**SINSW - JPPS
RESPONSE TO SUBMISSION PROGRAM AND TASKS**

Thank you for your email dated 22 November 2021, requesting the review and preparation of written responses to address concerns raised pertaining to the **SSD-23330227 - Upgrades to John Palmer Public School**.

Title
LANDSCAPE PLAN

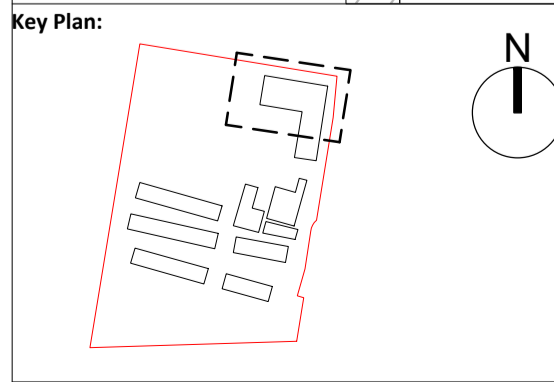
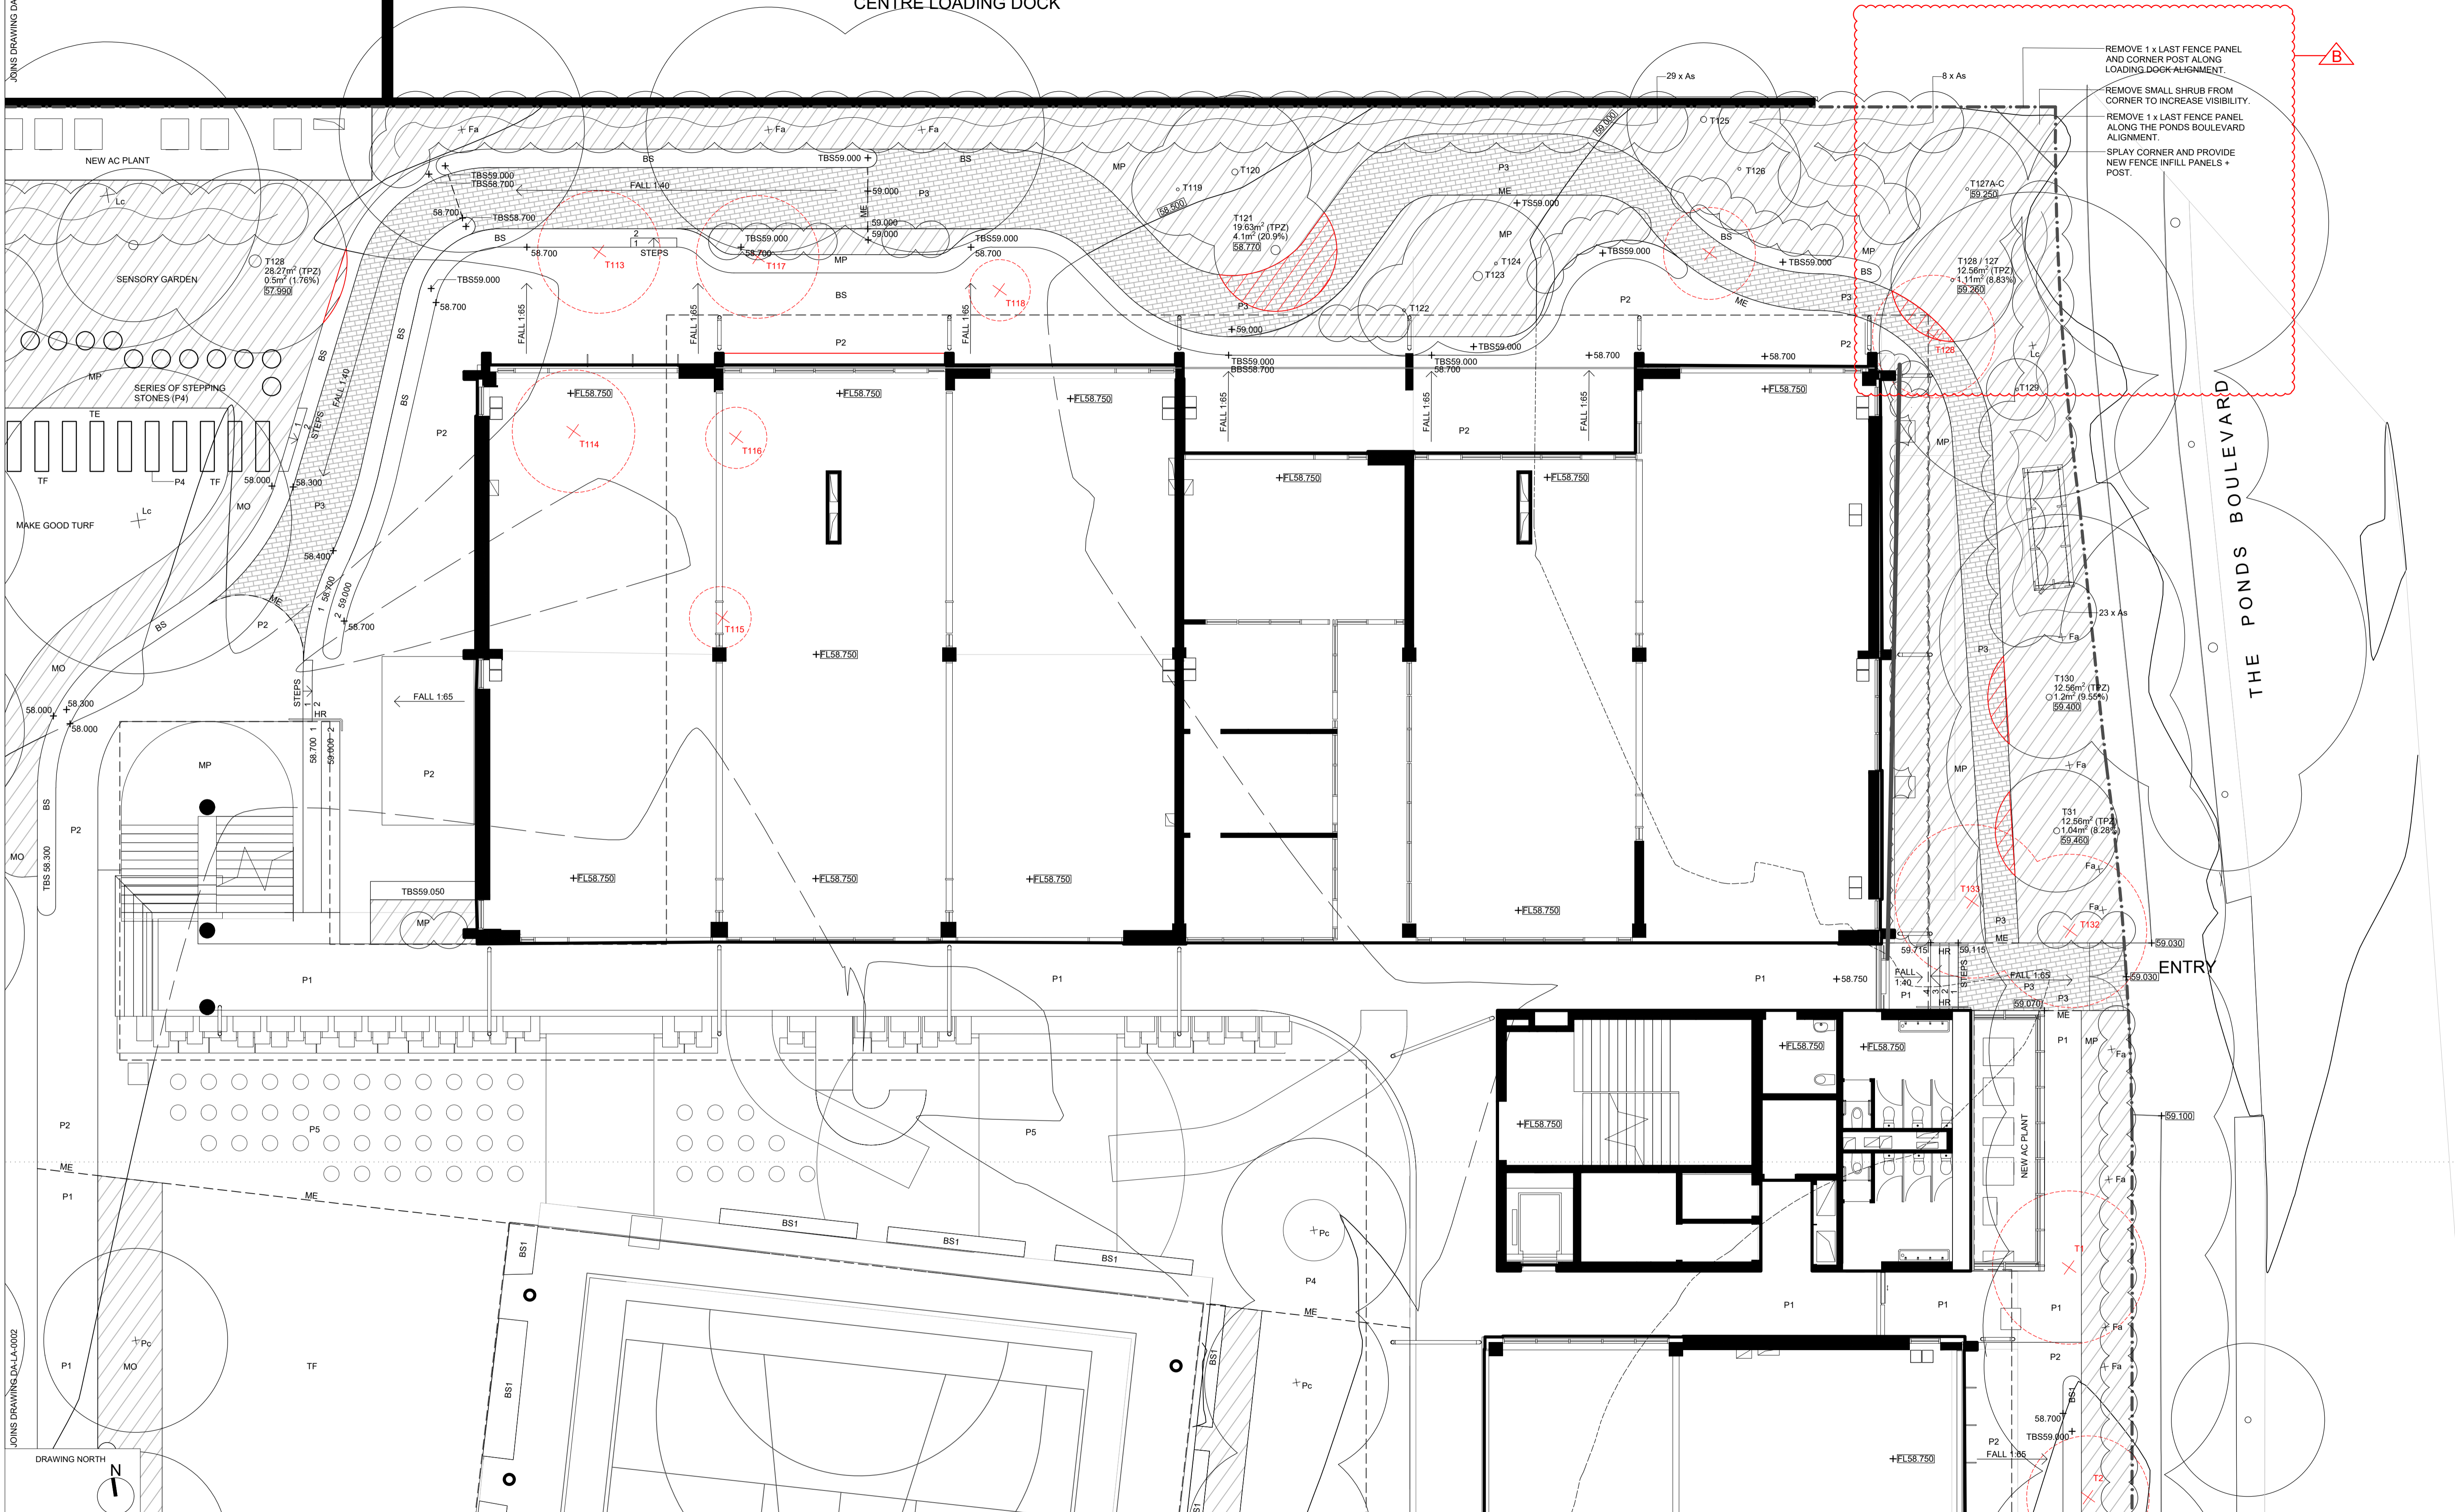
b. Splay: A pedestrian safety issue has been identified due to not having splay at the north-east boundary of the school with The Ponds Shopping Centre vehicular access along The Ponds Boulevard. It is necessary that a splay be provided by removing a few panels of the fence and landscaping to improve the line of sight for pedestrians at The Ponds Shopping Centre vehicular access. This will need to be reflected on an amended plan.

McIntosh & Phelps has amended the Landscape plans (Refer DA-LA-001 Rev. B and DA-LA-003 Rev. B) to show:

- Removal of 1 x last fence panel and corner post along the loading dock alignment
- Removal of 1 x last fence panel along The Ponds Boulevard alignment
- Removal of small shrub and local pruning to existing tree and shrub planting from corner location to increase visibility
- Splay corner and new fence infill panels and post aligned with splay

Drawing Number
DA-LA-0005

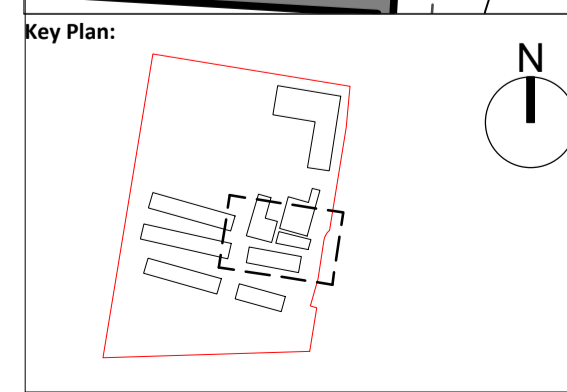
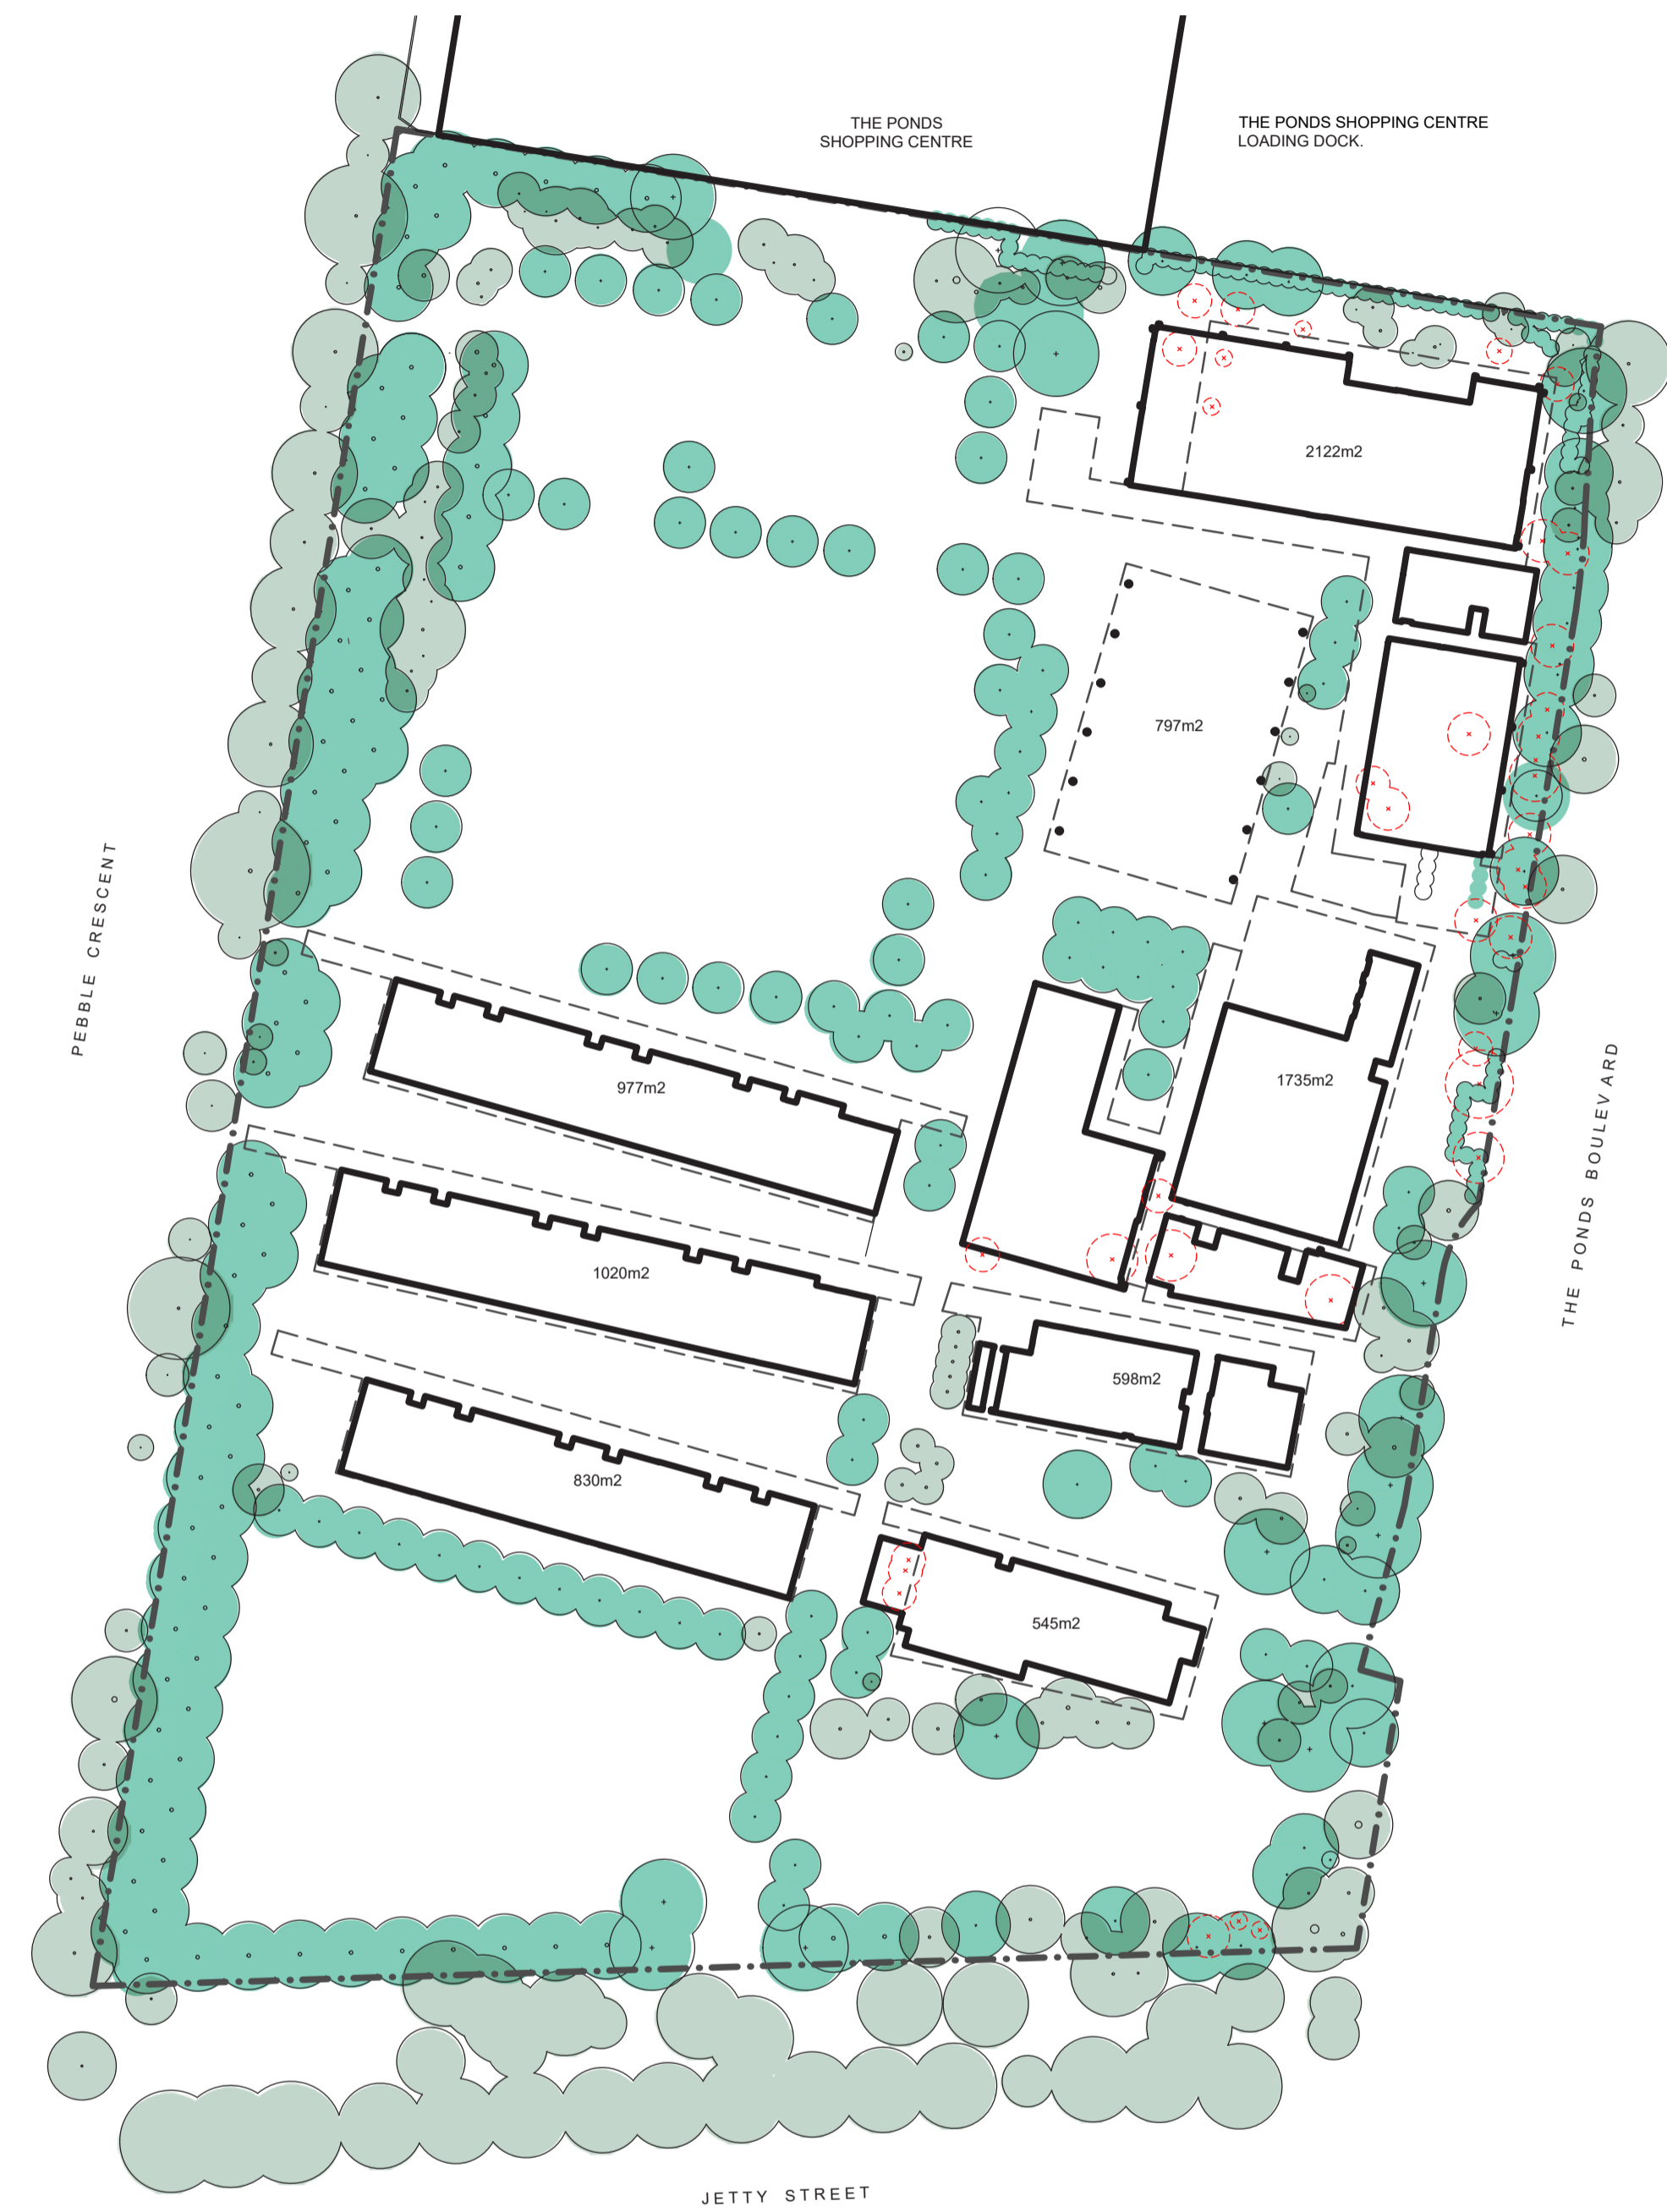
Screening vegetation around a padmount substation should be planted a minimum distance of 800mm plus half of the mature canopy width from the substation easement and have shallow / non-invasive roots. This is to avoid trees growing over the easement as falling branches may damage the cubicle and the electricity infrastructure as do tree roots. All vegetation is to be maintained in such a manner that it will allow unrestricted access by electrical workers to the substation easement all times.

McIntosh & Phelps has modified the location of screen planting species located around the padmount in accordance with the recommendations by Endeavour Energy; “a minimum distance of 800mm + 1/2 of the mature canopy width from the substation easement, and have shallow / non - invasive root systems” (Refer DA-LA-005 Rev. B).
